ASSESSMENT REPORT

STAGE 1 OF MONTEFIORE AGED CARE FACILITY MP 10_0044 MOD 2

This report is an assessment of a request to modify the Project Approval (MP10_0044) for the expansion of the Sir Moses Montefiore Jewish Home aged care facility at 100-120 King Street and 30-36 Dangar Street Randwick in the Randwick local government area.

Figure 6: Approved (top) and proposed (bottom) King Street elevation, Concept Approval building edge maximum height (required by FEAR 8) shown as red dashed line (Source: MP10_0044 and Proponent's application)

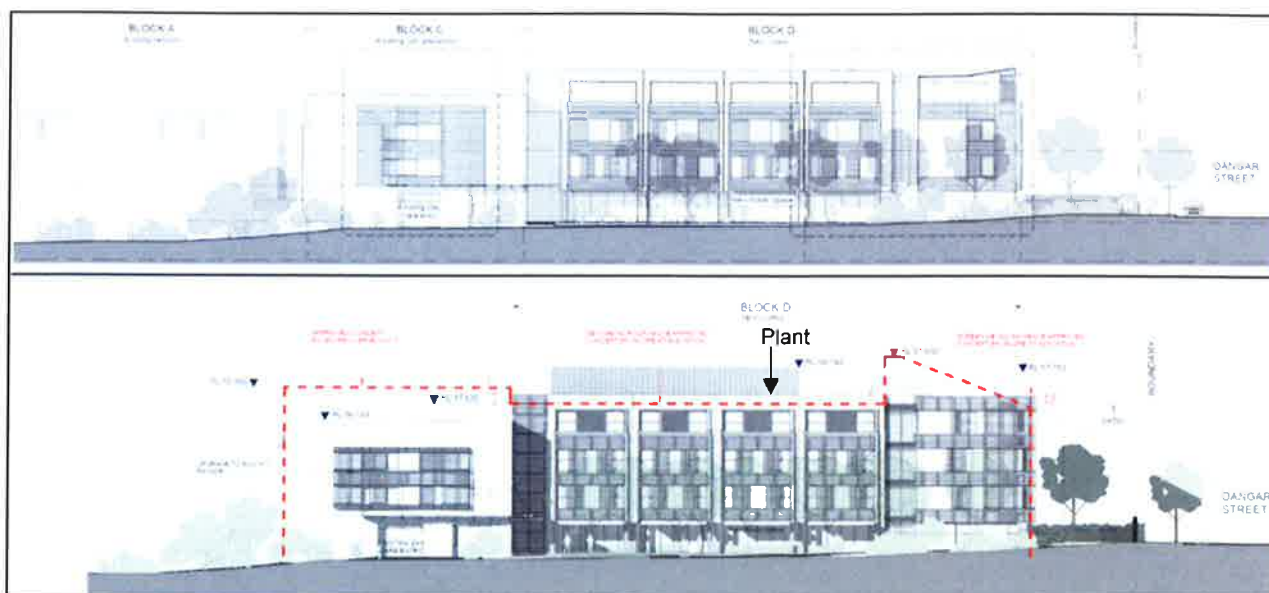
The modification includes the following minor height encroachments above the Concept Approval building envelope height (RL 57.75) at the building edge fronting King and Dangar Streets:

- 515 millimetres (mm) fronting Dangar Street, comprising a light weight architectural/façade screen
- 770 mm fronting King Street, comprising the building parapet.

Concern has been raised in public submissions and by Council the proposal exceeds the Concept Approval building envelope height and the encroachments adversely increase the bulk and visual impact of the building.

The Proponent has stated the 770 mm height exceedance along the King Street frontage is below the maximum height of Building D and adjoining Building C and is minor in nature. The 515 mm exceedance along the Dangar Street frontage extends less than a third of the façade, is lower than the maximum building envelope height (RL 61.63) and forms part of the architectural expression of the building.

The Department notes the architectural screen fronting Dangar Street provides an appropriate architectural treatment to the corner of the building, frames windows at each level of the building and achieves appropriate horizontal and vertical proportions. Similarly, the metal parapet fronting King Street provides an appropriate termination/capping to the elevation and architecturally unifies the four bays fronting the public plaza.

The Department considers the 770 mm and 515 mm encroachments above the RL 57.75 height limit are acceptable as:

- the building is setback 19.5 m from King Street and 10 m from Dangar Street and when viewed from the street, the encroachments are minor and are unlikely to be noticed
- the proposed building edge heights are lower than the Project Approval building edge heights as shown at **Table 2**
- the architectural screen fronting Dangar Street is contained within a relatively small proportion of the overall facade
- the architectural screen and the metal parapet are lightweight constructions that are architecturally integrated into the overall design of the building.

Figure 7: the top floor of the Concept Approval (left) and the proposed modification including setbacks in response to FEAR 8 (right) (Base source: MP10_0188 MOD 2 and the subject modification application)

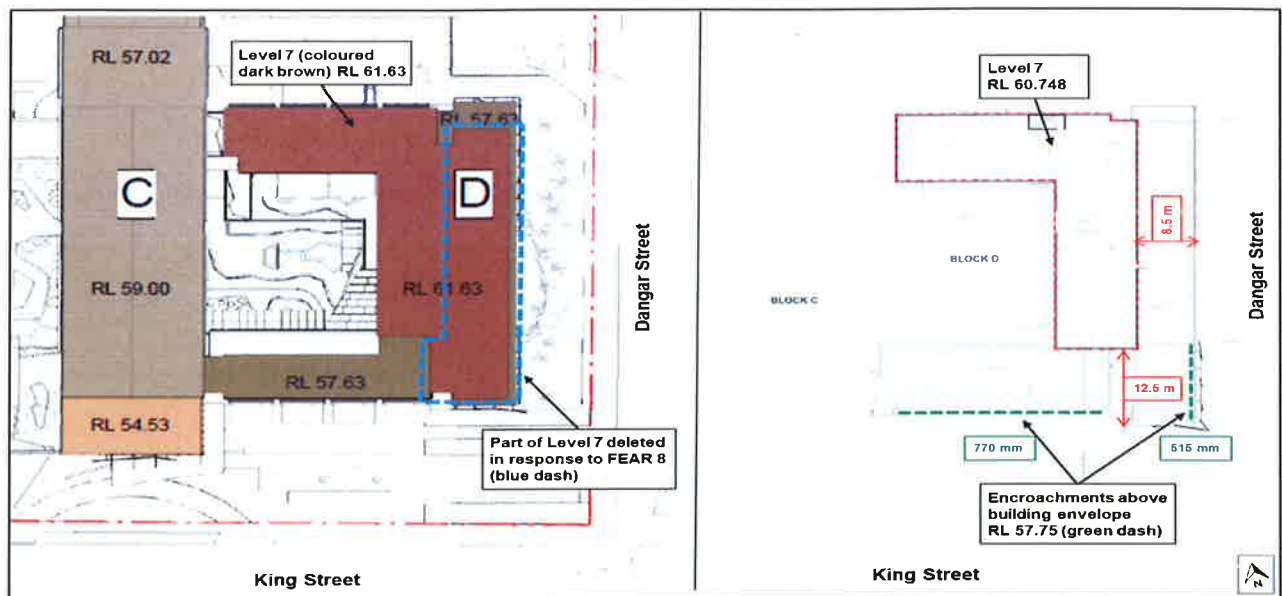
In its assessment of modification 2 of the Concept Approval, the Commission concluded the top floor of Building D was overly dominant and should be amended so it does not have an adverse visual impact on Dangar Street.

The Commission therefore imposed ToA 6 and FEAR 8, which stipulate the following building height parameters for Stage 1:

- Building D shall not exceed a maximum building height of RL 61.63
- the top storey of Building D shall be set back (above RL 57.75 at the building edge) so it is not visible from Dangar Street
- the height of plant and lift overrun shall not exceed 0.9 m above RL 61.63.

The top floor of Building D has been set back to address the Concept Approval requirements as shown at **Figure 7**.

Figure 8: Modified King Street (top) and Dangar Street (bottom) elevations and the location of height encroachments (Base source: the subject modification application)

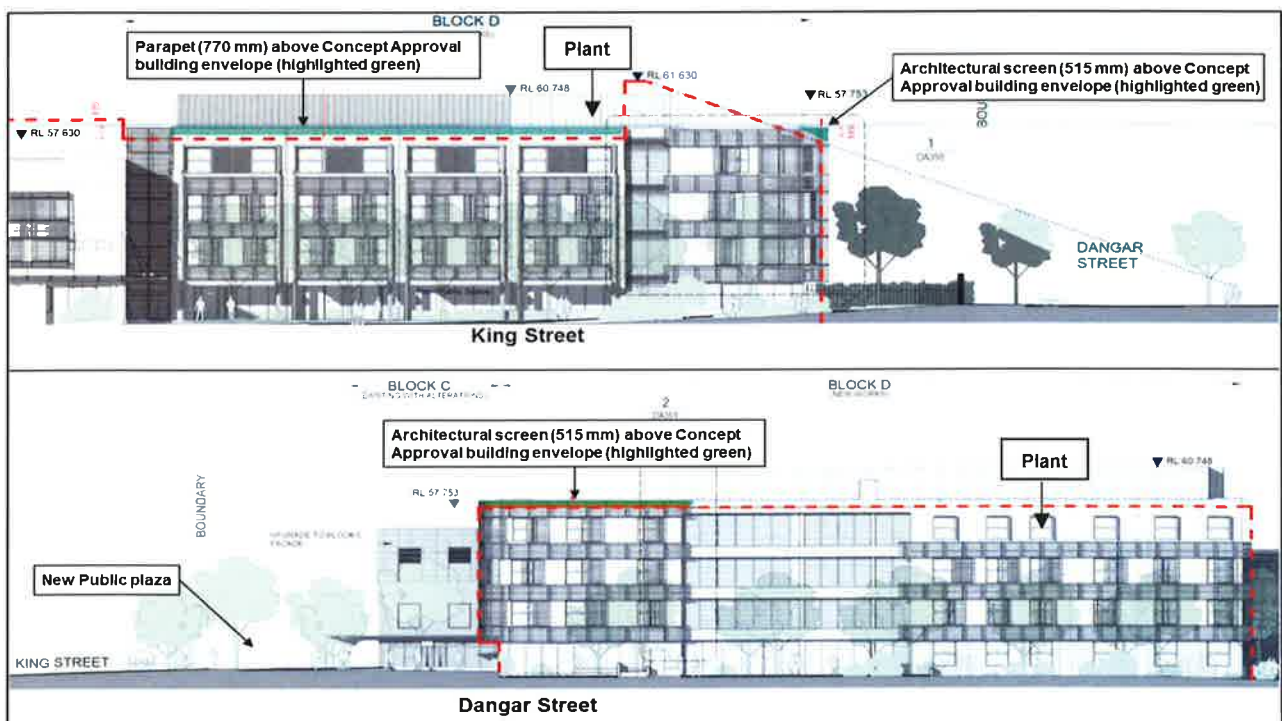
The non-complying sections of the building are highlighted in green in **Figures 7 and 8**.

The Department also considers strict compliance with the height control would not result in any significant improvements in terms of the building's overall design and appearance. In light of the above, the Department considers the proposed building heights fronting King and Dangar Streets are acceptable and would not have an adverse impact on the surrounding area, appear overbearing or visually dominant.
